Stonehenge and Avebury World Heritage Site Coordination Unit (WHSCU)

Anne Carney, Stonehenge and Avebury World Heritage Site Partnership Manager

The Stonehenge and Avebury World Heritage Site Coordination Unit (WHSCU) welcomes the opportunity to submit comments on National Highways response to the Statement of Matters relating to the A303 Stonehenge Amesbury to Berwick Down Scheme (the Scheme). A key role of the WHSCU is to offer impartial and independent advice on issues relating to the implementation of the Stonehenge, Avebury and Associated Sites World Heritage Site Management Plan (WHS Management Plan) and its overarching aim, the protection of the WHS and its OUV. The WHS Management Plan represents the UK's commitment to its international obligations under the UNESCO WHC [REP8-065].

PROPOSED BORED TUNNEL - (WORK No. 1F)

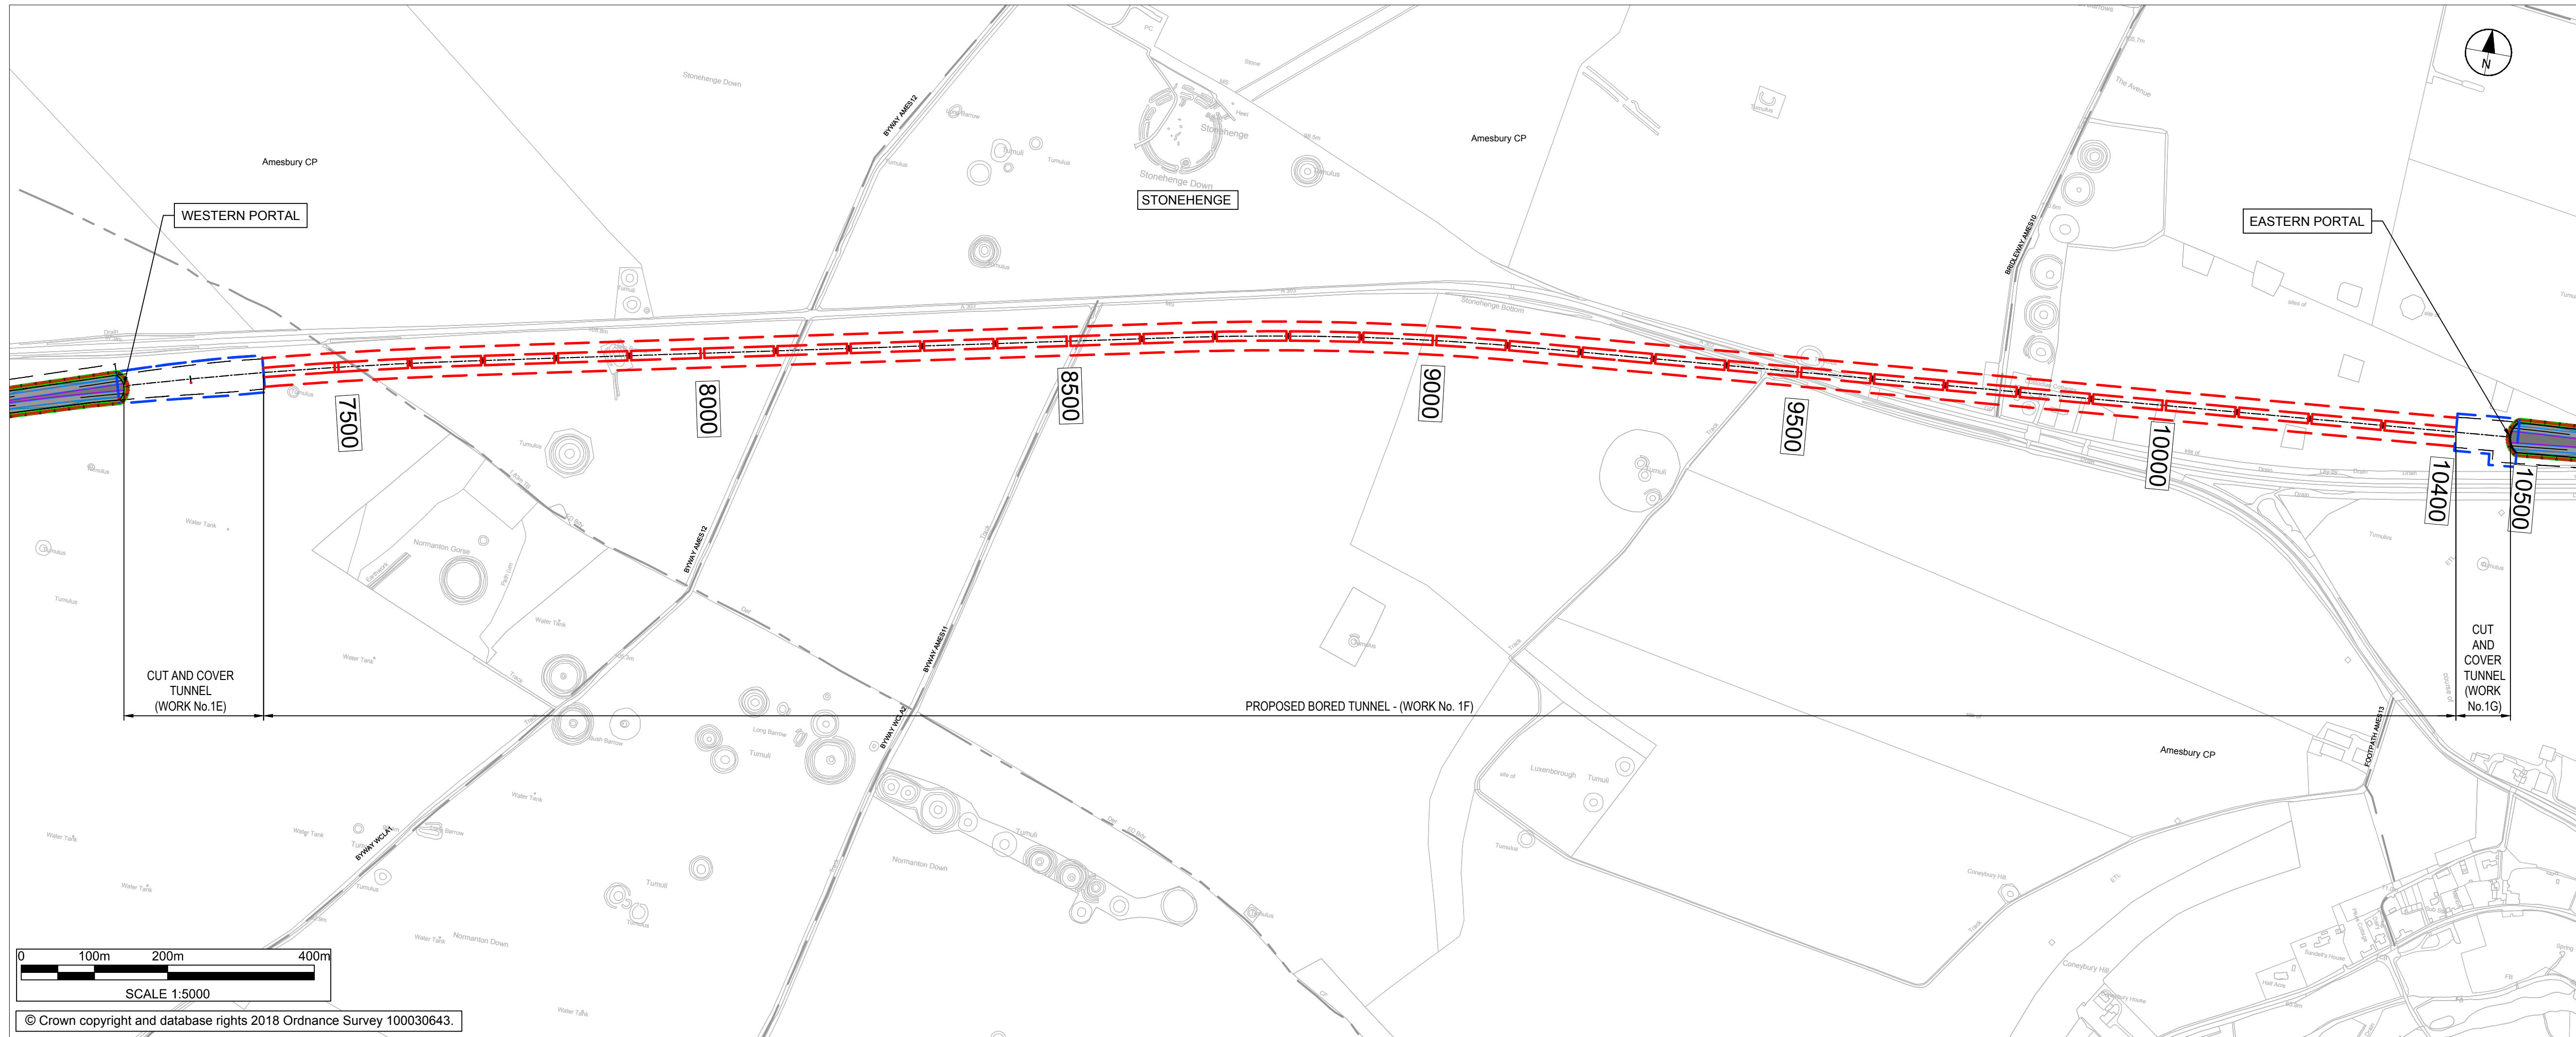
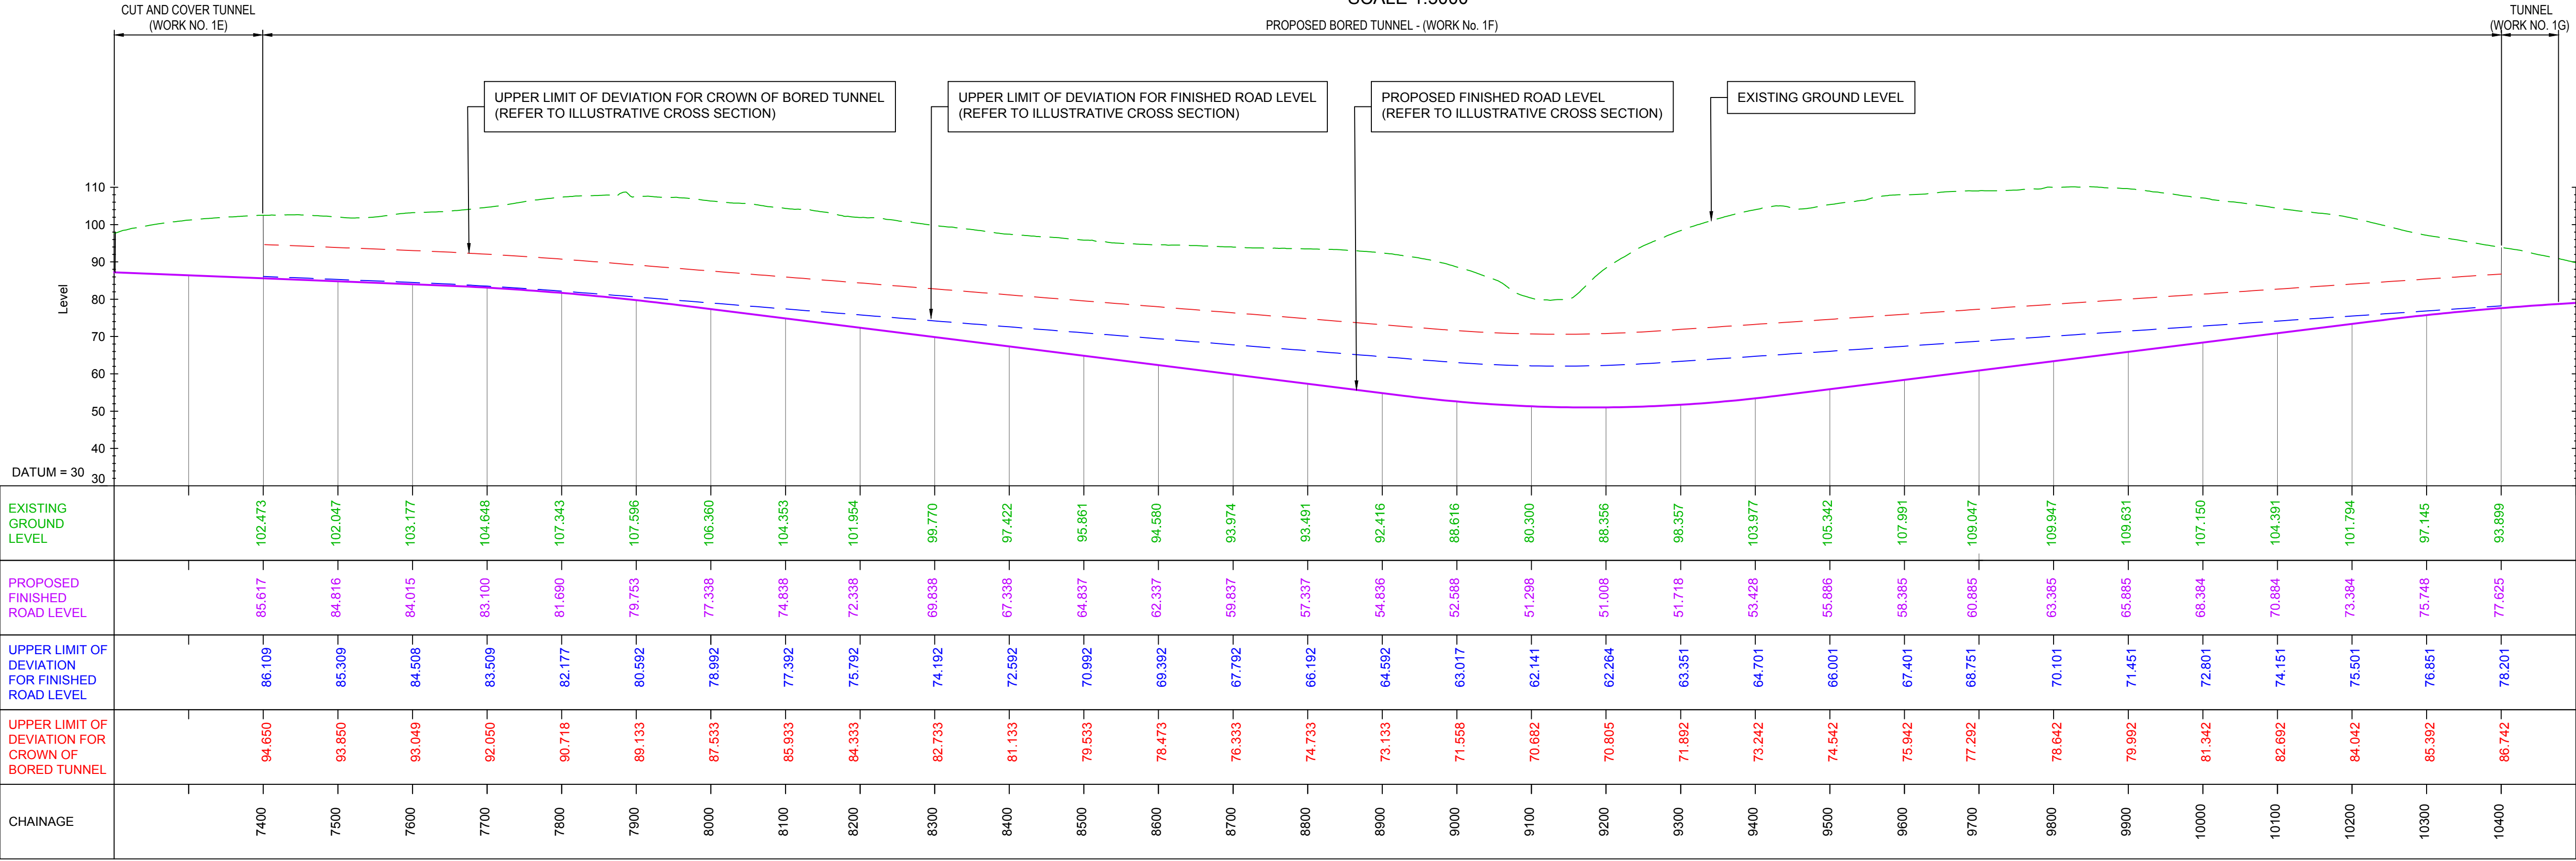
Even with a part-bored tunnel solution, and despite design refinements, the current road proposal would require substantial mitigation related to above ground infrastructure in any attempt to align it to the Management Plan, vision, aims and policies. This applies particularly to the western portal and expressway. Covering the gap between the tunnel canopy and the Green Bridge would enhance both visual and physical links between barrow groups and other archaeological features as well as their settings. It would also provide better opportunities for exploration of the WHS and movement through it, enhancing visitors experience and understanding of the WHS. It would not, however, prevent the loss of archaeological evidence or the effects of major element of infrastructure on the WHS elsewhere.

Extending the bored tunnel out of the WHS would provide the best solution to adequately protect the OUV of the property.
